**Planning Department
Transportation Development Services**

October 19, 2015

Re: Taco Bell Renovations
4815 4th St., NW
Traffic Circulation Layout
Engineer's/Architect's Stamp dated 10-12-15 (F14-D071)

TCL-1

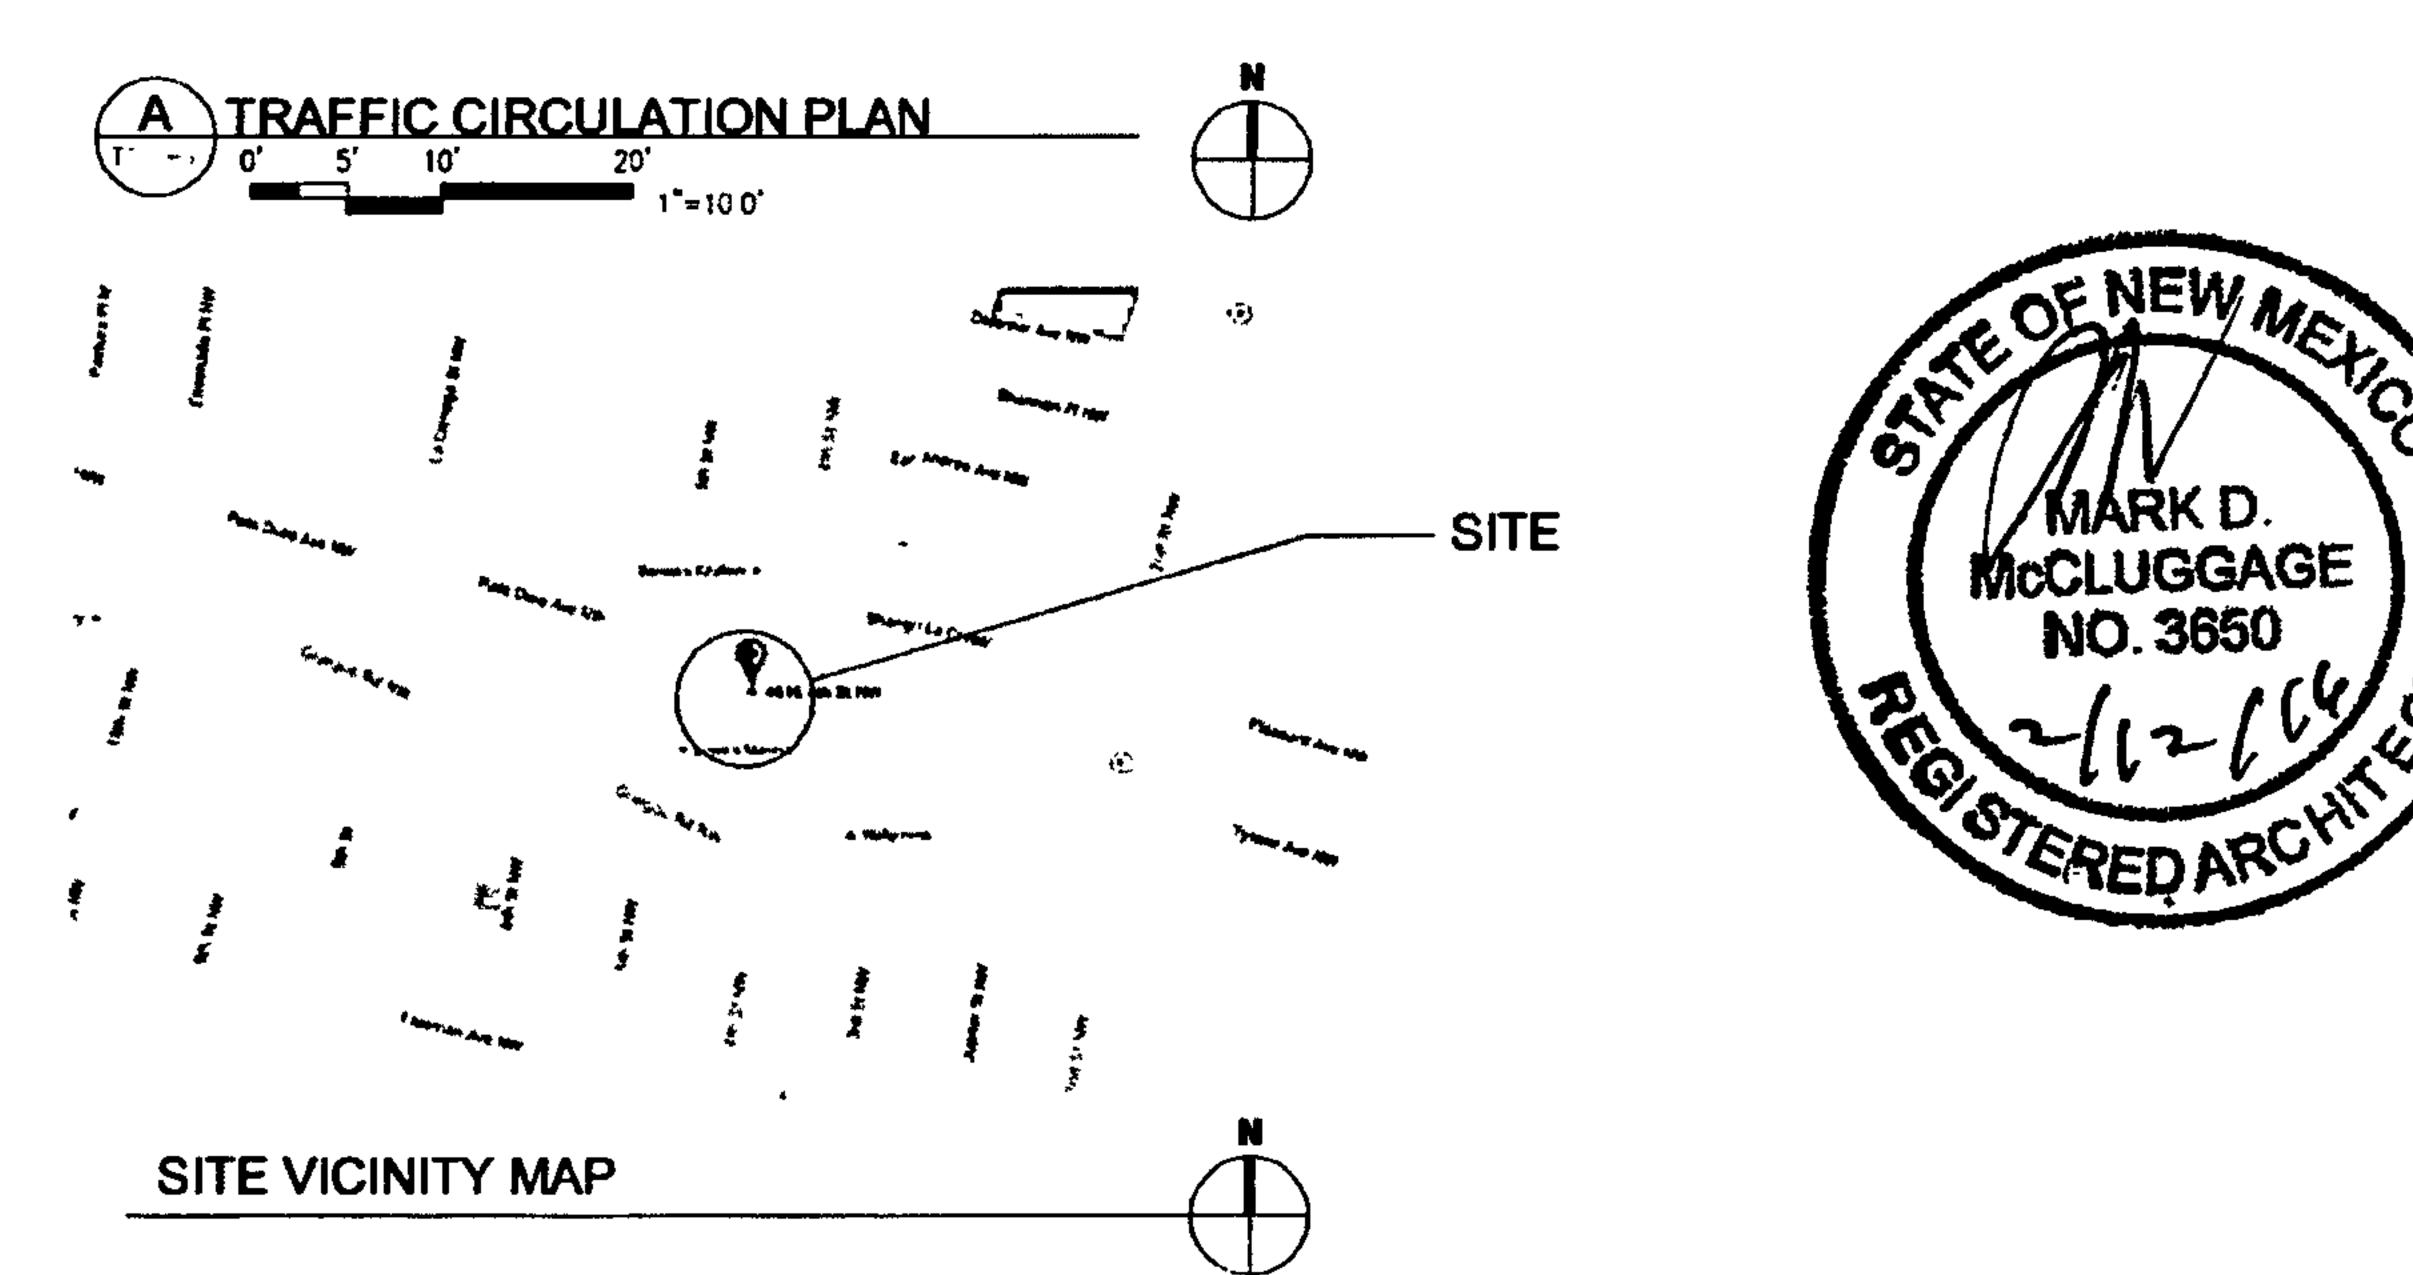
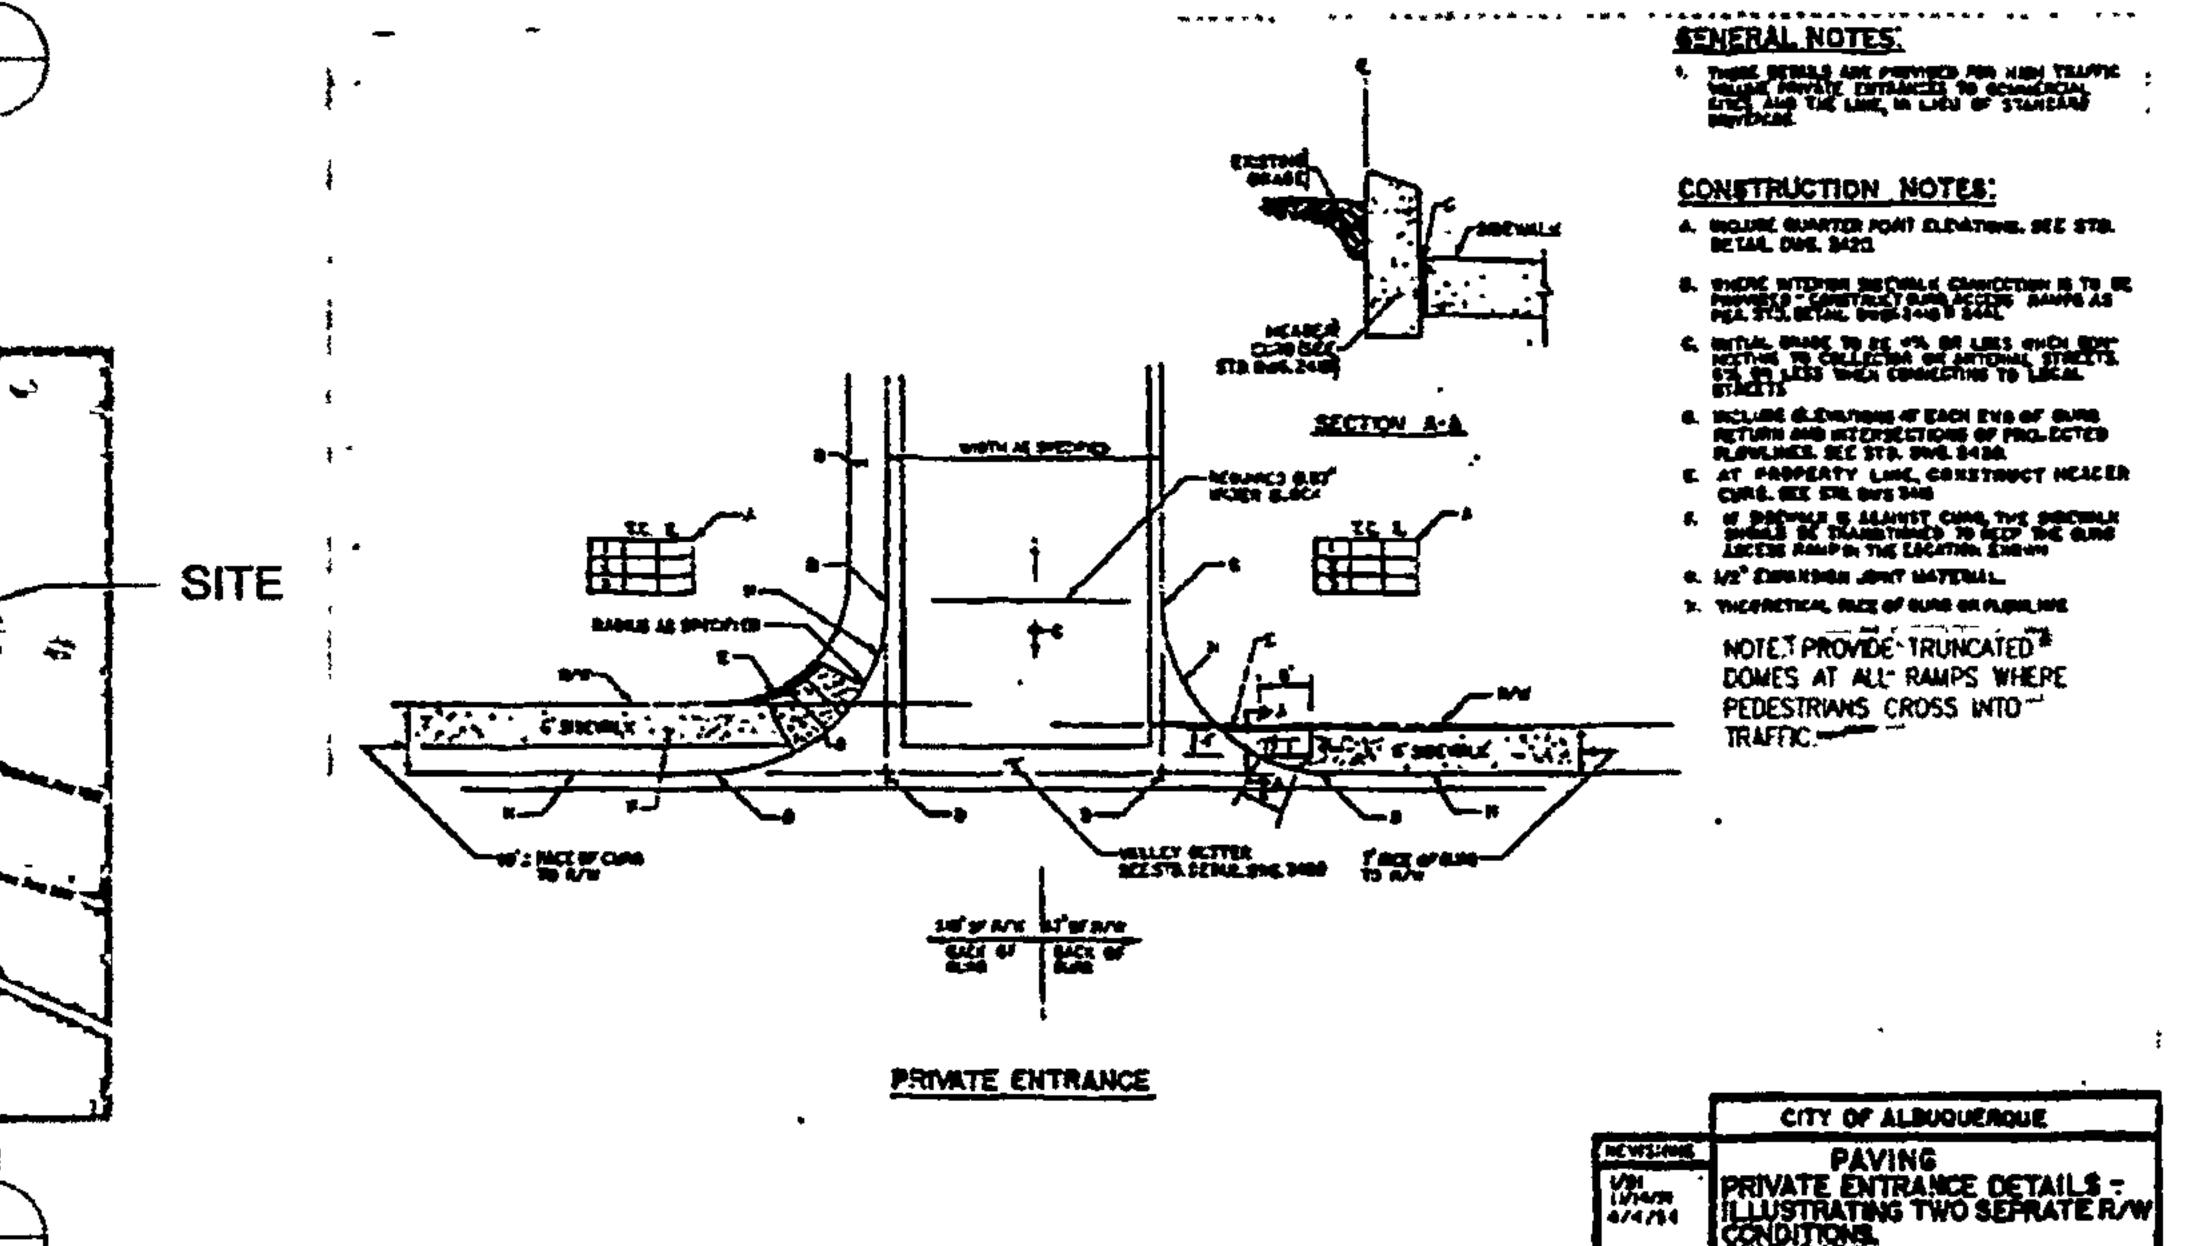
1. Please detail sidewalk and drive pad ramps on Palo Duro Ave. and 4th St. per COA City Standard specifications. ADA truncated domes need to be called out at all ramps where pedestrians cross onto traffic lanes.
2. Please provide a sight distance exhibit (see the *Development Process Manual, Chapter 23, Section 3, Part D.5 Intersection Sight Distance*). Please provide this detail for drive pad entrances/exits on Palo Duro Ave. and 4th St..

3. Please add the following note to the clear sight triangle: "Landscaping and signage will not interfere with clear sight requirements. Therefore, signs, walls, trees, and shrubbery between 3 and 8 feet tall (as measured from the gutter pan) will not be acceptable in this area." This detail is for drive pad entrances/exits on Palo Duro Ave. and 4th St..
4. Please include two copies of the traffic circulation layout at the next submittal.
